U-17-002

APPROVAL OF LOCATION WINDMILL MESA PARK

A request by Widefield School District No. 3 for an approval of location to allow for the expansion of an existing public park. The site is located on the east side of Bradley Road, south of Marabou Way. (Parcel No. 65121-00-012) (Commissioner District No. 4) (Nina Ruiz)

1 West Parking Lot - Layout Plan

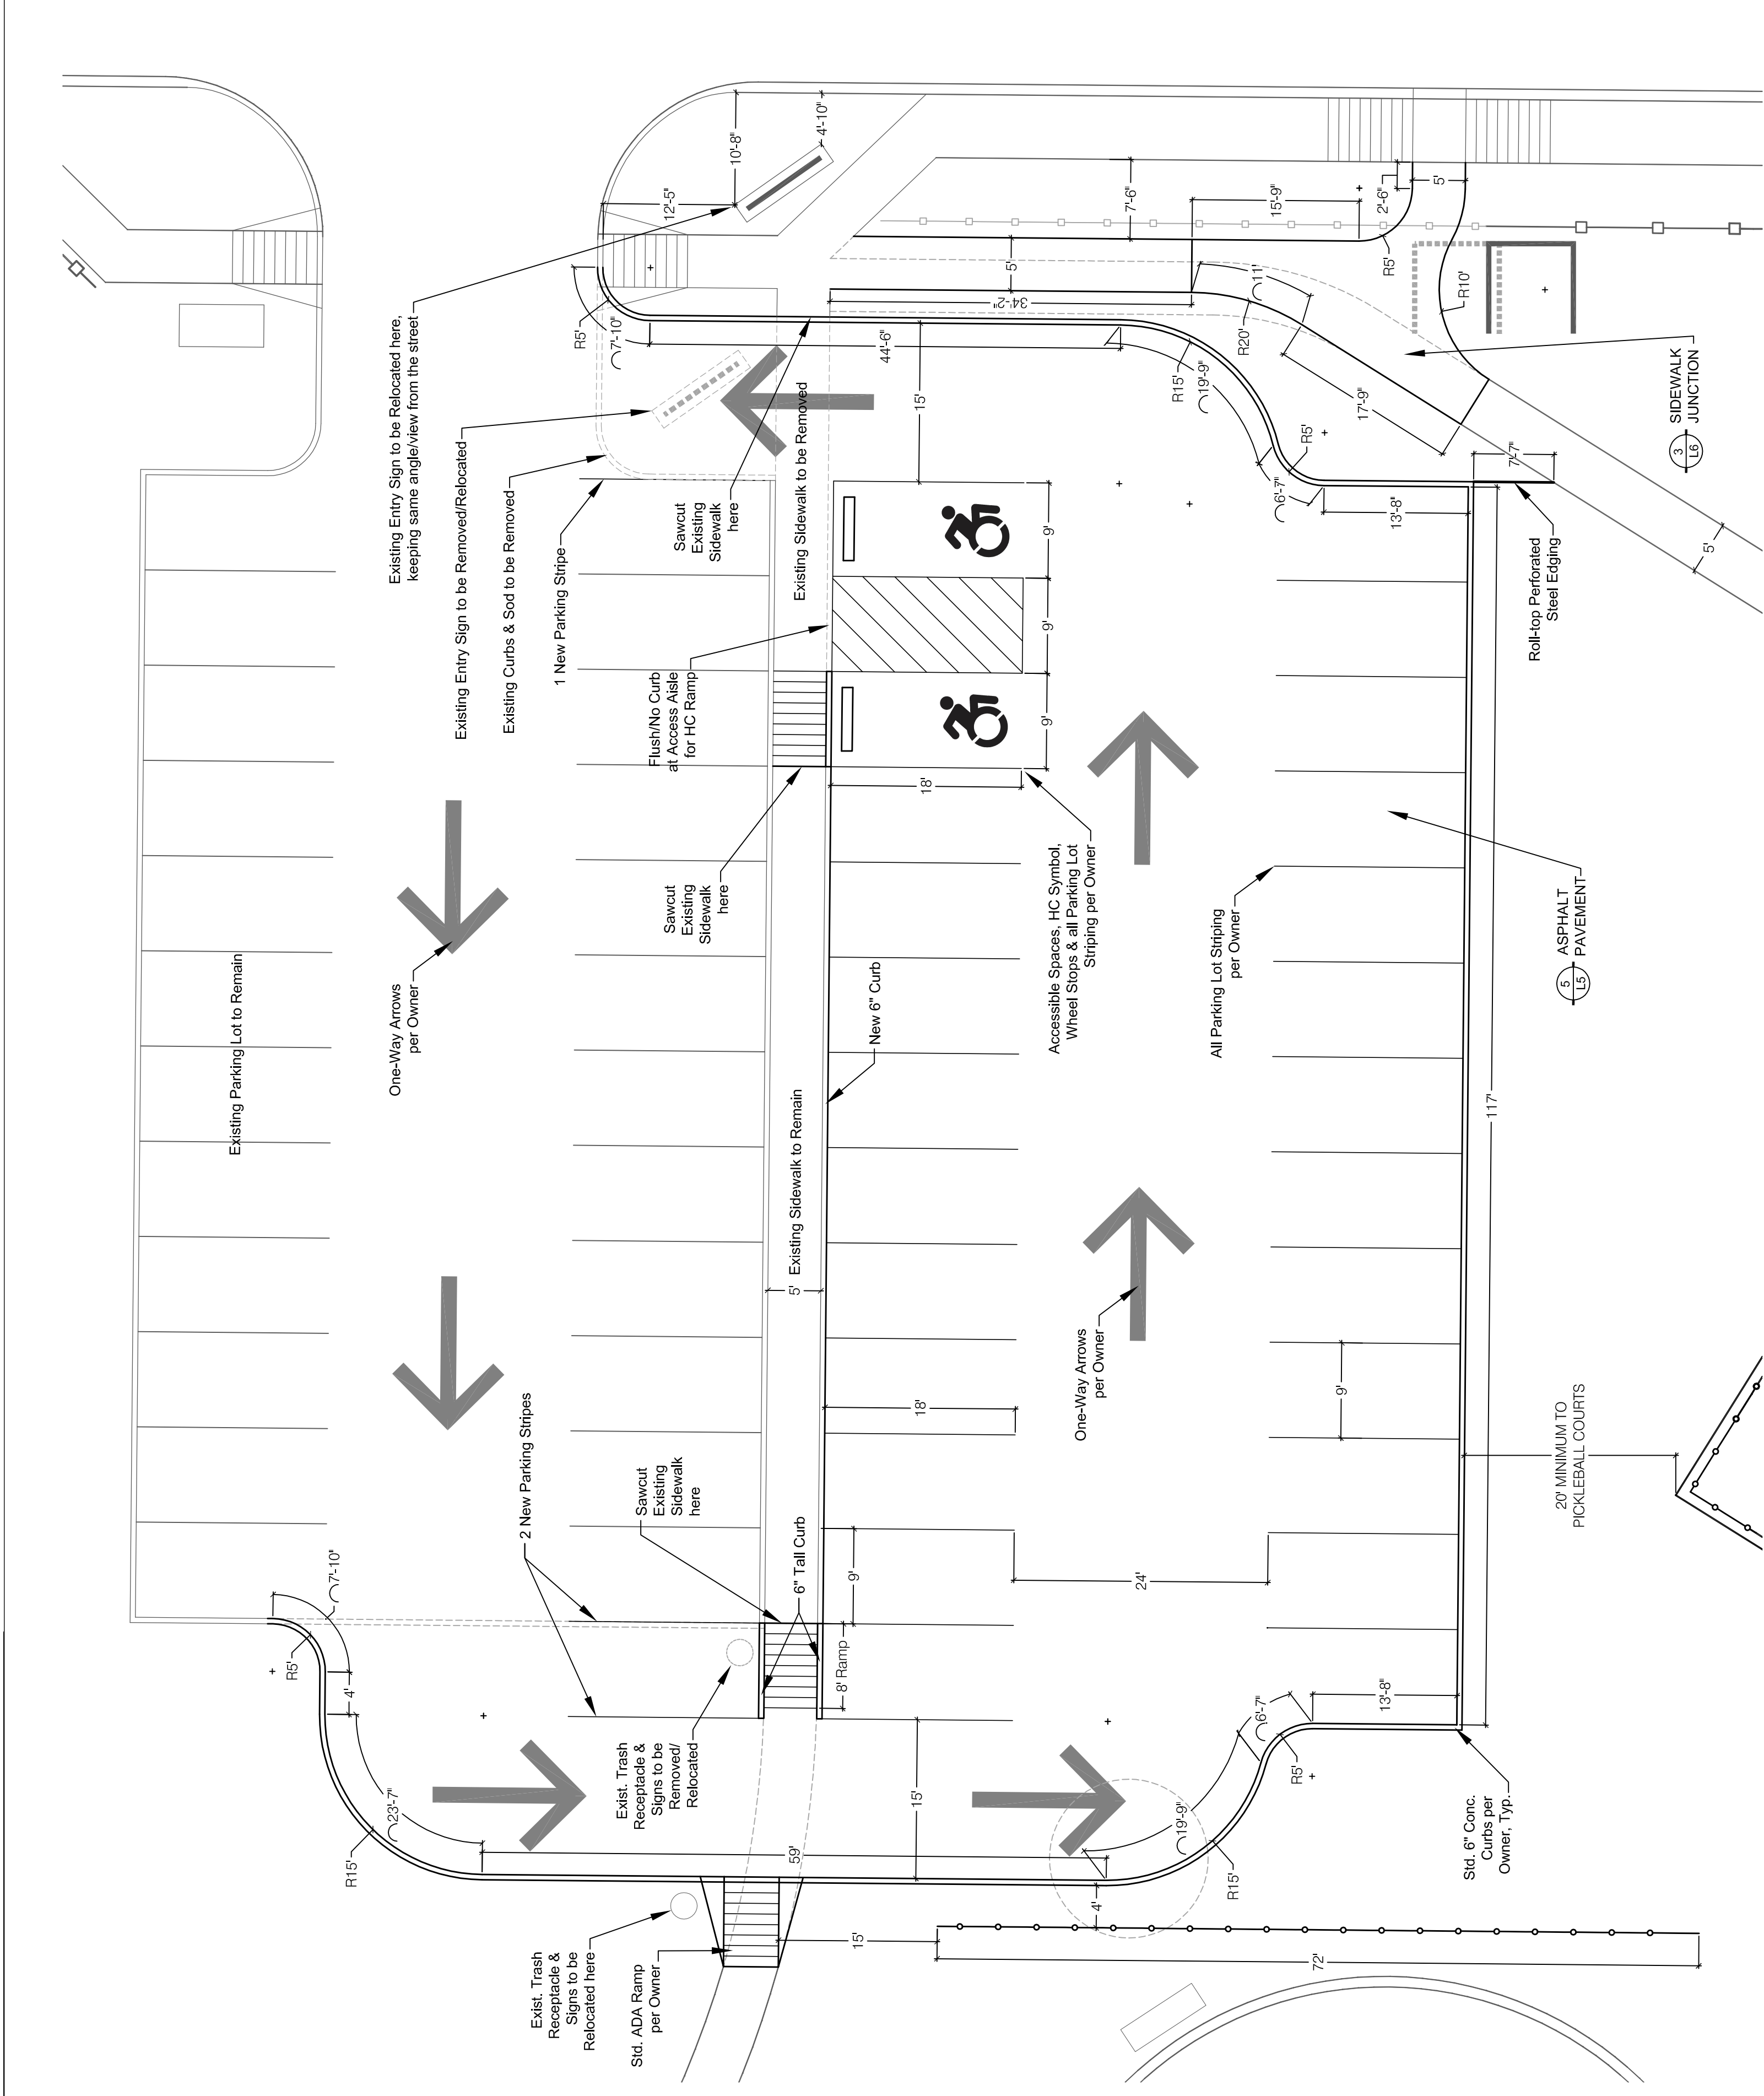
Comments: THE PROPOSED WESTERN PARKING LOT AND ACCESS ROAD DIRECTLY AFFECTS THE SAFETY AND VALUE OF TWO HOUSES I OWN ON BRADLEY CIRCLE, ONE OF WHICH HAS A PROPERTY BORDER WITH THE PARK. THE PROPOSED PARKING LOT AND ACCESS ROAD WILL GREATLY EFFECT THE PROPERTY
(FOR ADDITIONAL COMMENTS, PLEASE ATTACH ANOTHER SHEET.)
